From: Sue Howell <Sue.Howell@arun.gov.uk>
Sent: 01 October 2020 14:57
To: Planning.Responses <Planning.Responses@arun.gov.uk>
Cc: Michael Eastham <Michael.Eastham@arun.gov.uk>
Subject: RE: Planning Consultation on: Y/82/20/RES

Application ref: Y/82/20/RES

Description: Approval of reserved matters following outline consent Y/80/16/OUT for 4.5ha of residential development comprising of 3.4ha of land for the erection of 100 No. dwellings (up to 30 (30%) affordable housing) together with 1.1ha of land set aside for public open space, strategic landscaping, 2.2ha of public open space, green corridors with vehicular access from Ford Lane & pedestrian/cycle access only from North End Road (resubmission following Y/19/20/RES). This application may affect the setting of listed buildings, affects the character & appearance of the Church Lane, Yapton Conservation Area & affects a Public Right of Way. This site falls within Strategic Site SP2 (Zero Rated).

Summary recommendation: Recommend **approval** of hard and soft landscape details contained within this **Y/82/20/RES with the exception of the LEAP detail still required for submission and approval**, following outline consent Y/80/16/OU

Detailed Play Provision - LAP 1

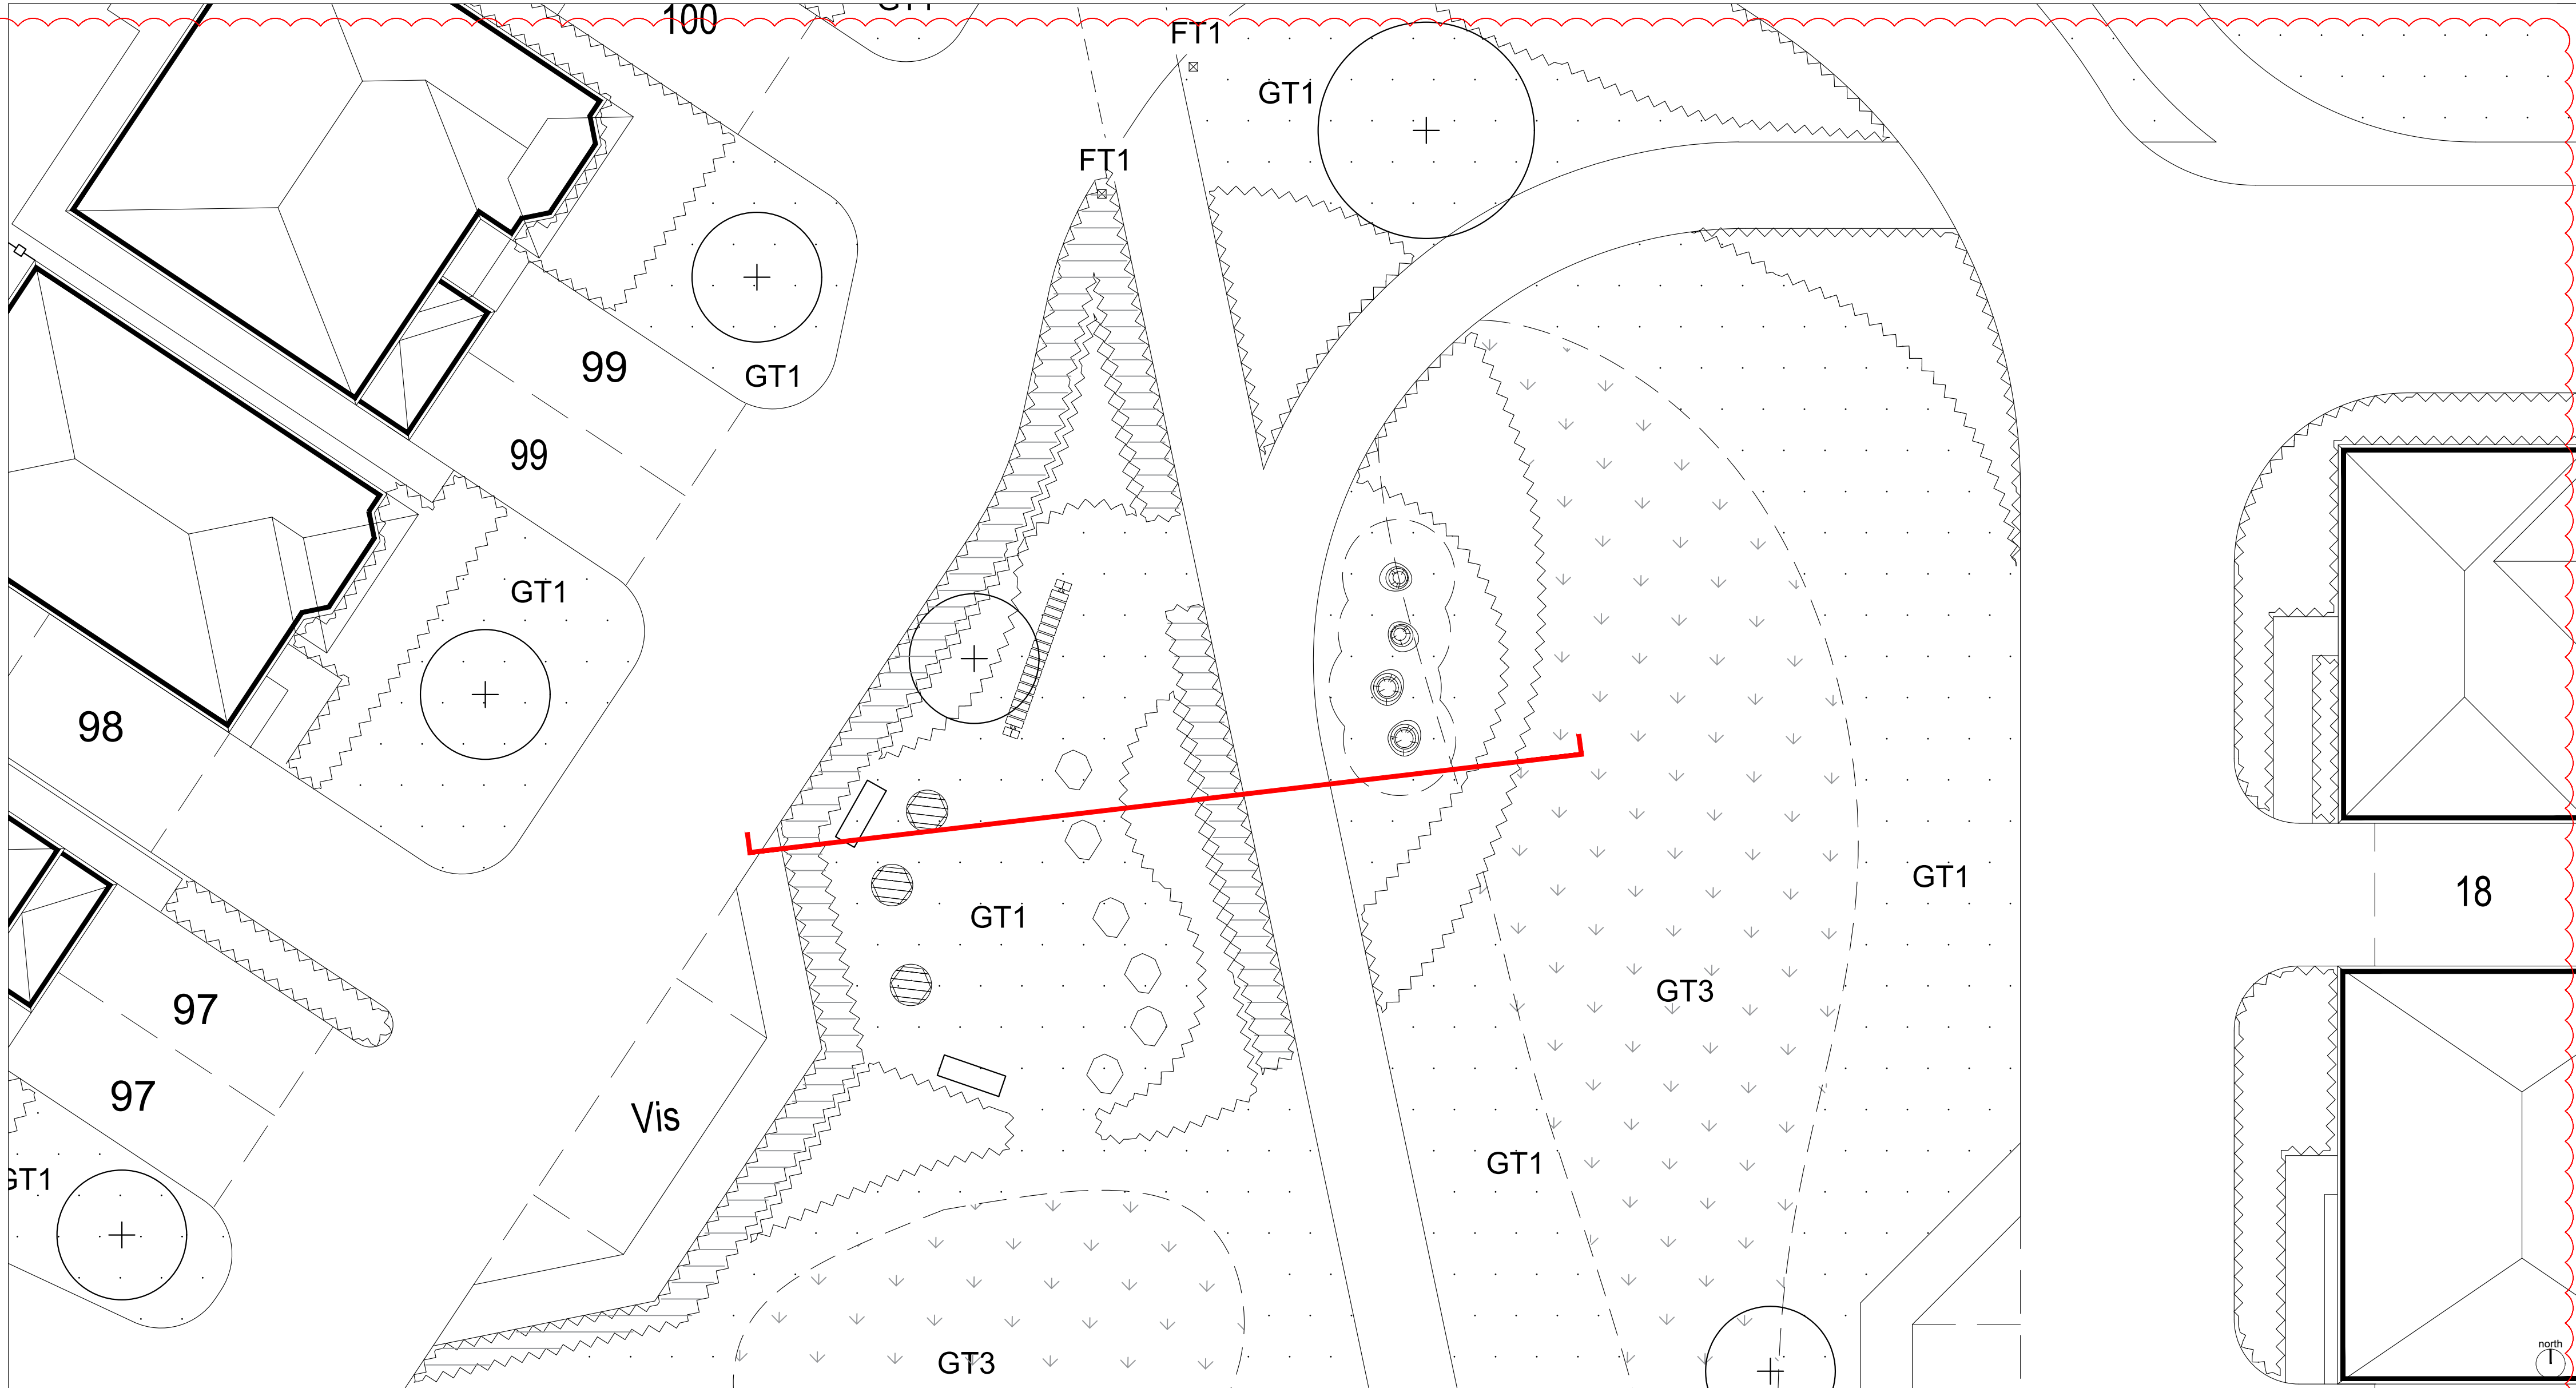
The drawings show 2no LAP in detail and 1no LEAP. The Laps are detailed in Detailed Play provision Lap 1 0502 Rev PL05 and LAP 2 0503 Rev PL05 of which I would recommend approval for providing two well thought out and imaginative schemes for this development, my only comment would be possibly to add litter bins to these details alongside the proposed seats.

Drawing Title: Detailed Play Provision - LEAP
Purpose of Issue: As shown@A1Feb | 2020

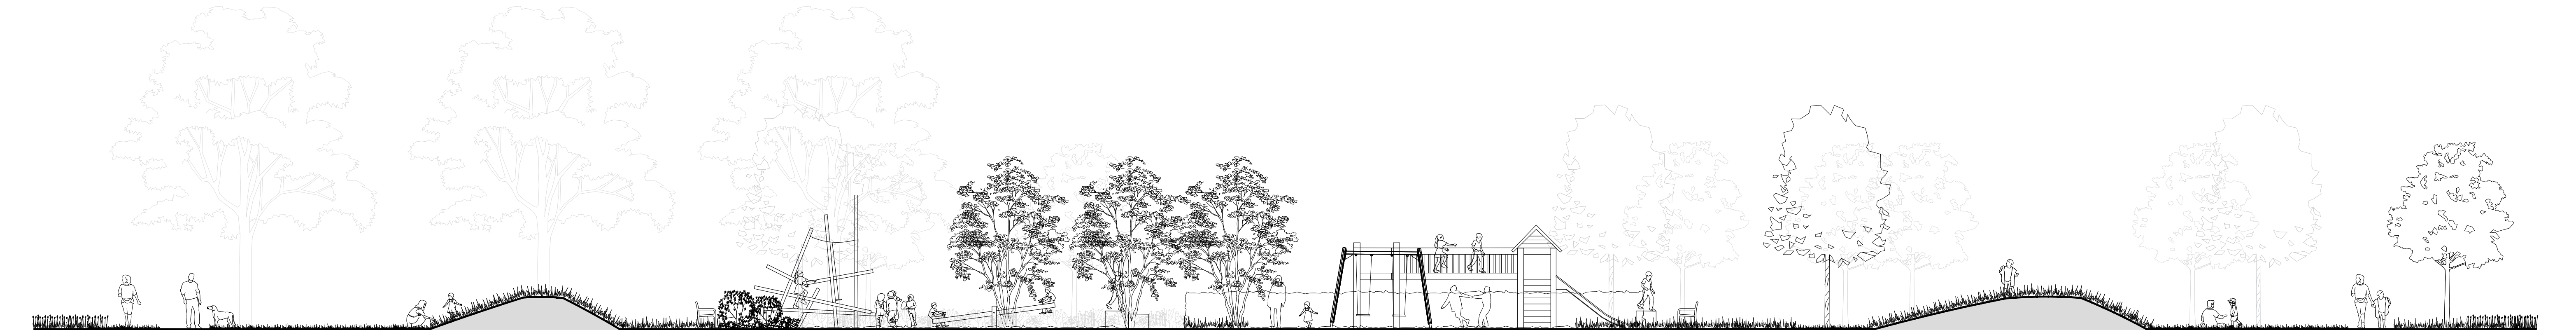
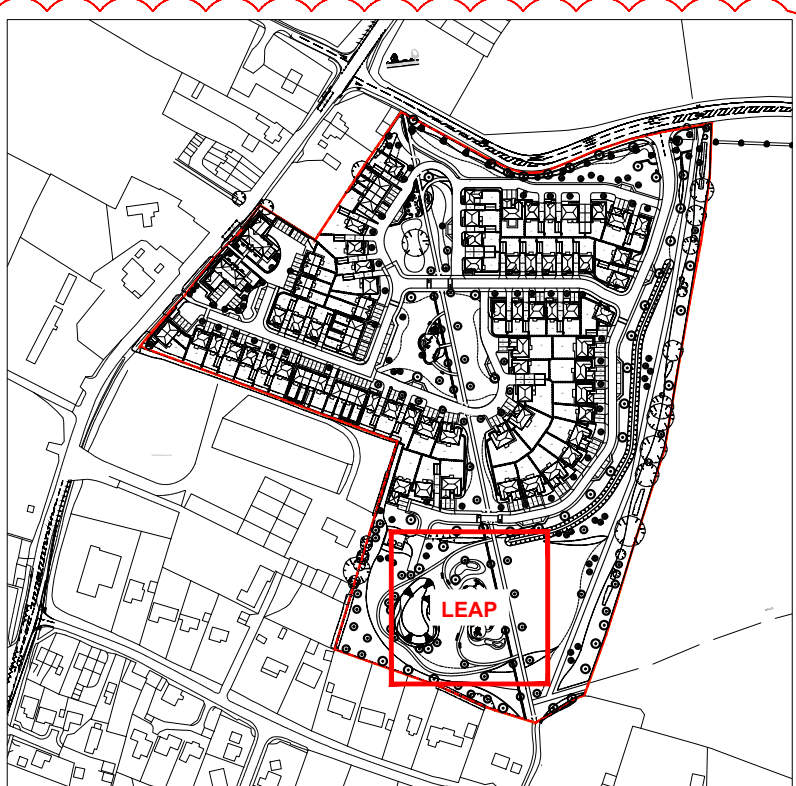
There does not appear to have been submitted LEAP plans which show the proposals for the shown LEAP and the play provision offered. We would need to see submitted for approval the equipment choice, surfacing, fencing and connectivity to the pathway network for this formal play area.

We note the requirement for the large SuDS infiltration basin shown within the POS and the inclusion of marginal planting to integrate this as a positive design feature within the scheme. There has now been submitted cross sections of this along with boundary treatment. We would still advise that ROSPA or similar body are consulted re the proximity to the indicated LEAP.
